FW: SIPSON GARDEN CENTRE - 67666/APP/2015/2413

Further to my email dated 2 October, I provide below the applicant's Highway Consultants WSP response to highway issues raised by the Highway Officer (and in turn by the GLA and TfL). We refer to the Highway Officer's paragraph lettering:

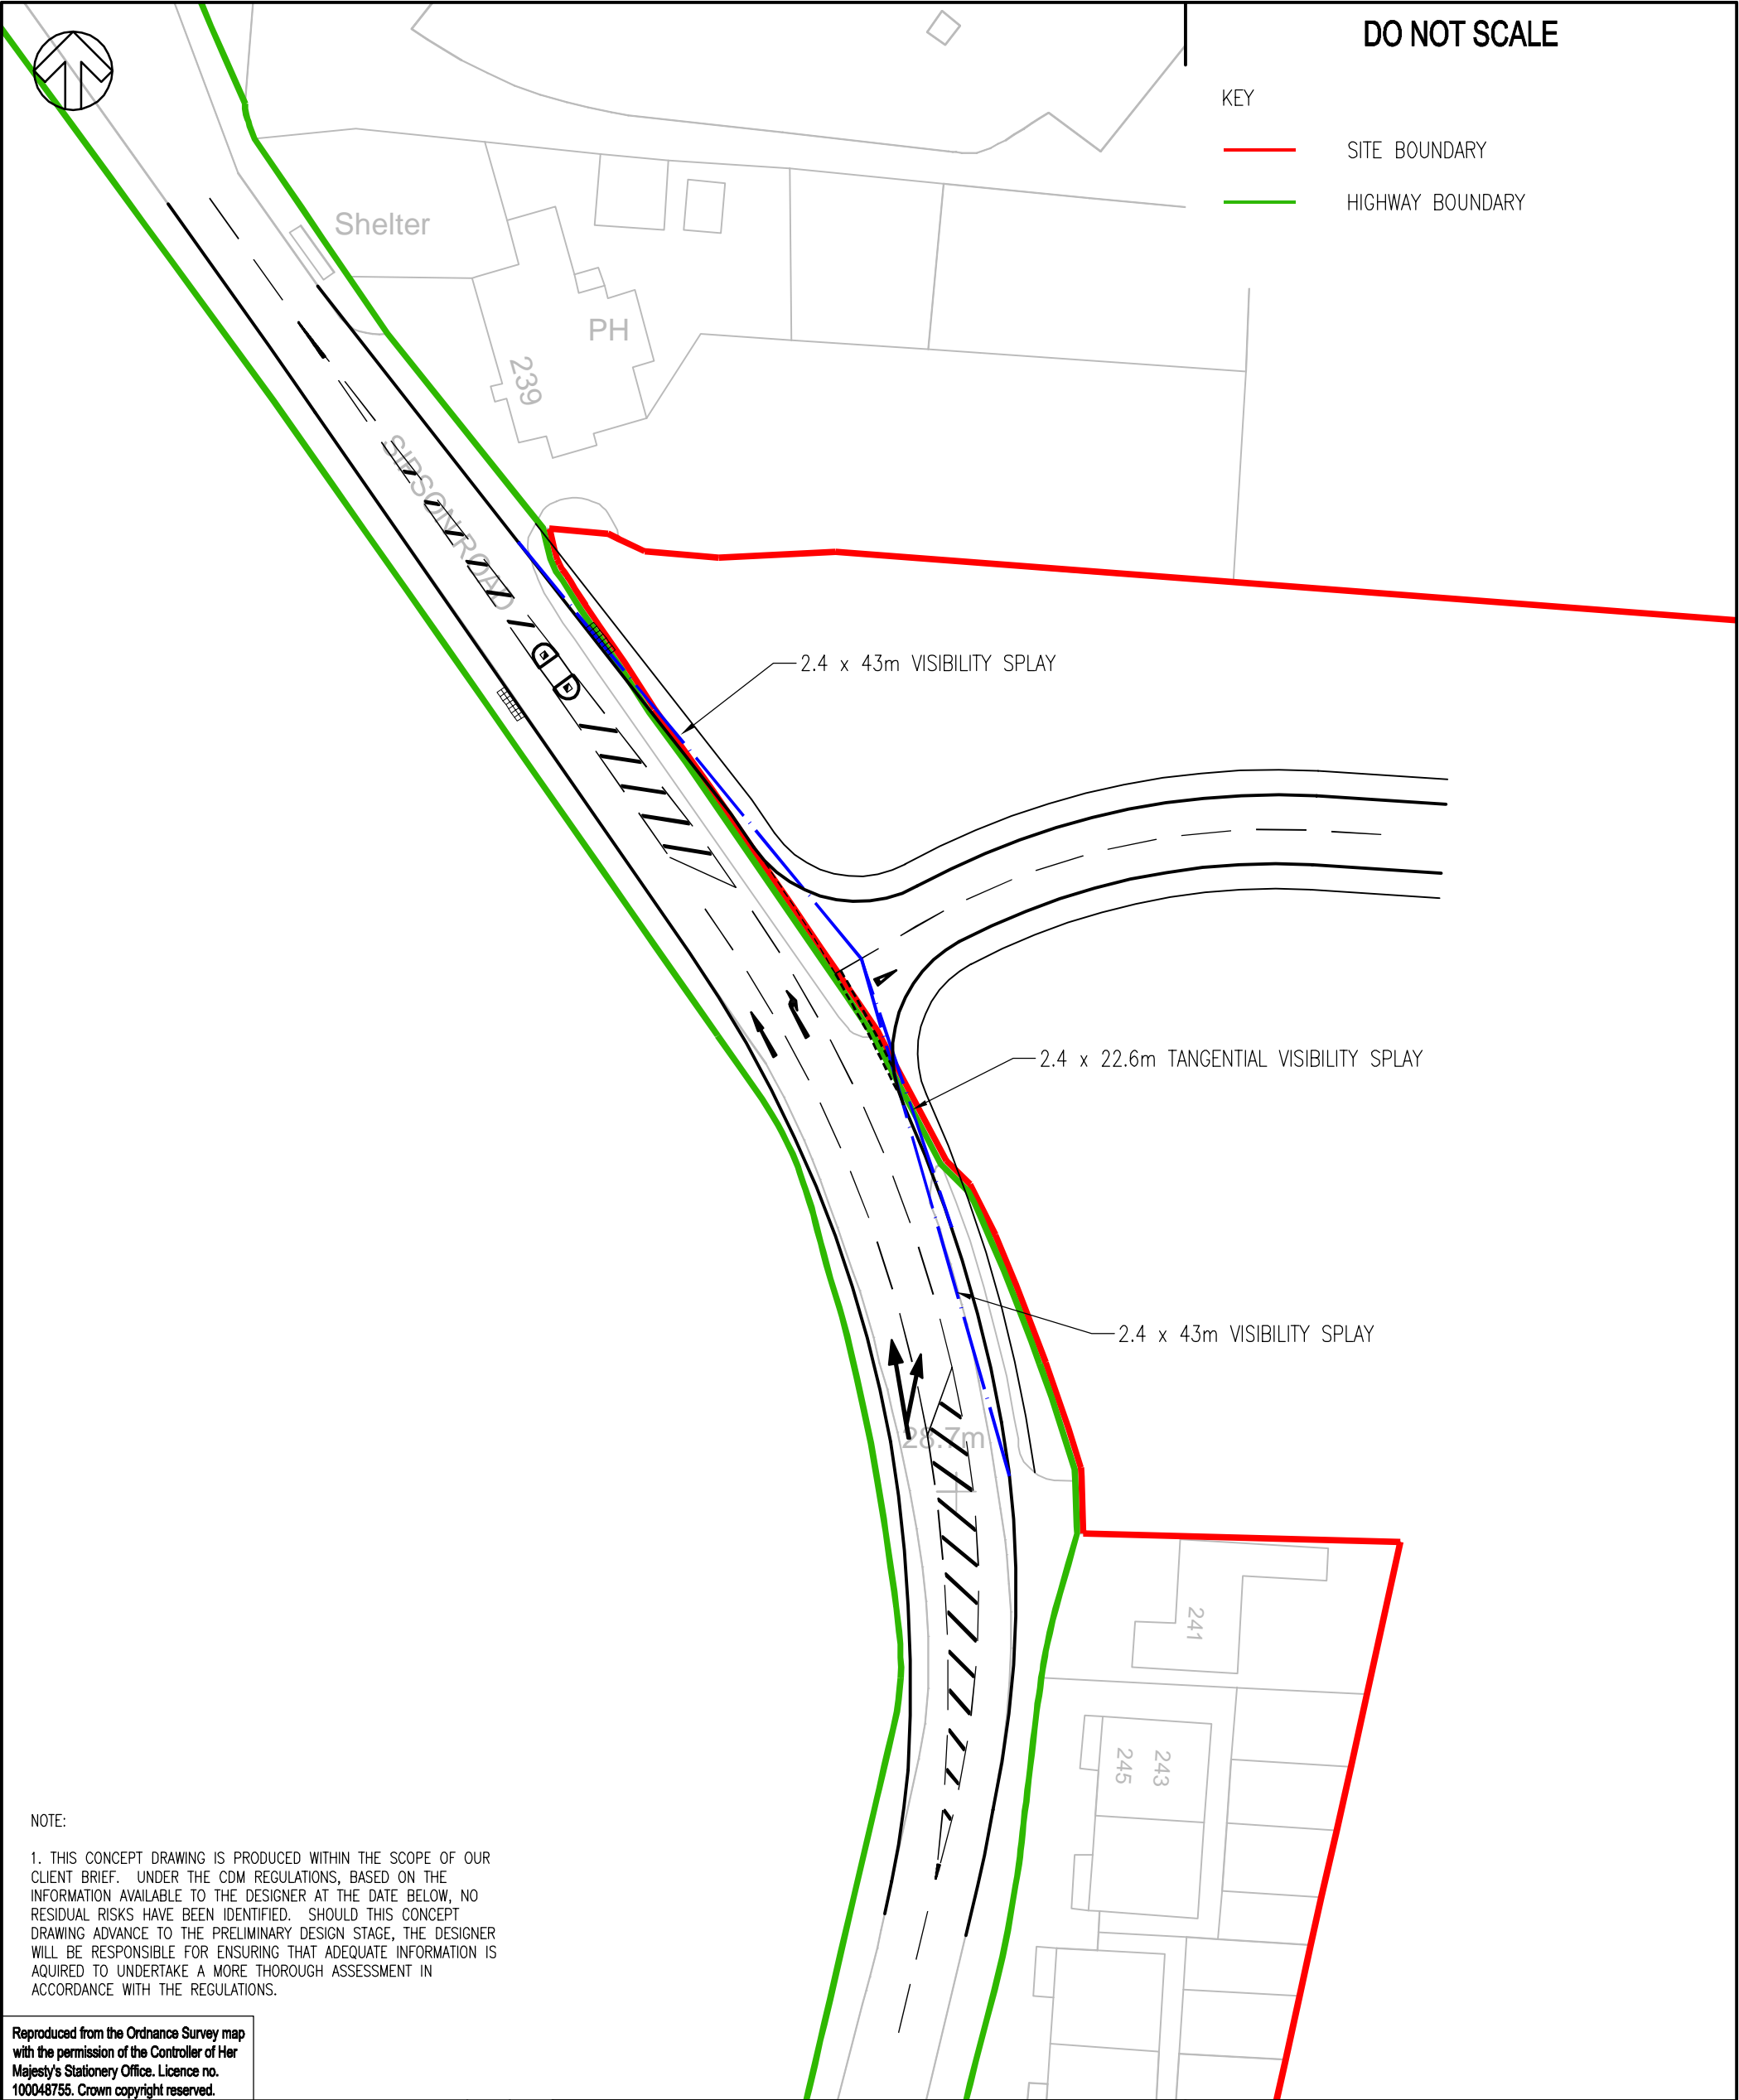
D: Swept Paths: It is suggested that swept paths should have 300mm error margin – this is not something that has been previously required. Reference is made to refuse vehicles encroaching onto opposing traffic lanes (see attached). The junction is designed to the same standard to the junction that was agreed for the previous application and therefore there is no reason why this is not acceptable now. From the attached it can be seen that there is run-over but this was considered acceptable to the frequency of such movements and that good forward visibility is provided. If the Council insist on 300mm error margin and no over-run then the junction will need to be widened, which will make the junction wider and be to the detriment of pedestrians crossing the access; however, primarily this was not required previously and nor was it a reason for refusal.
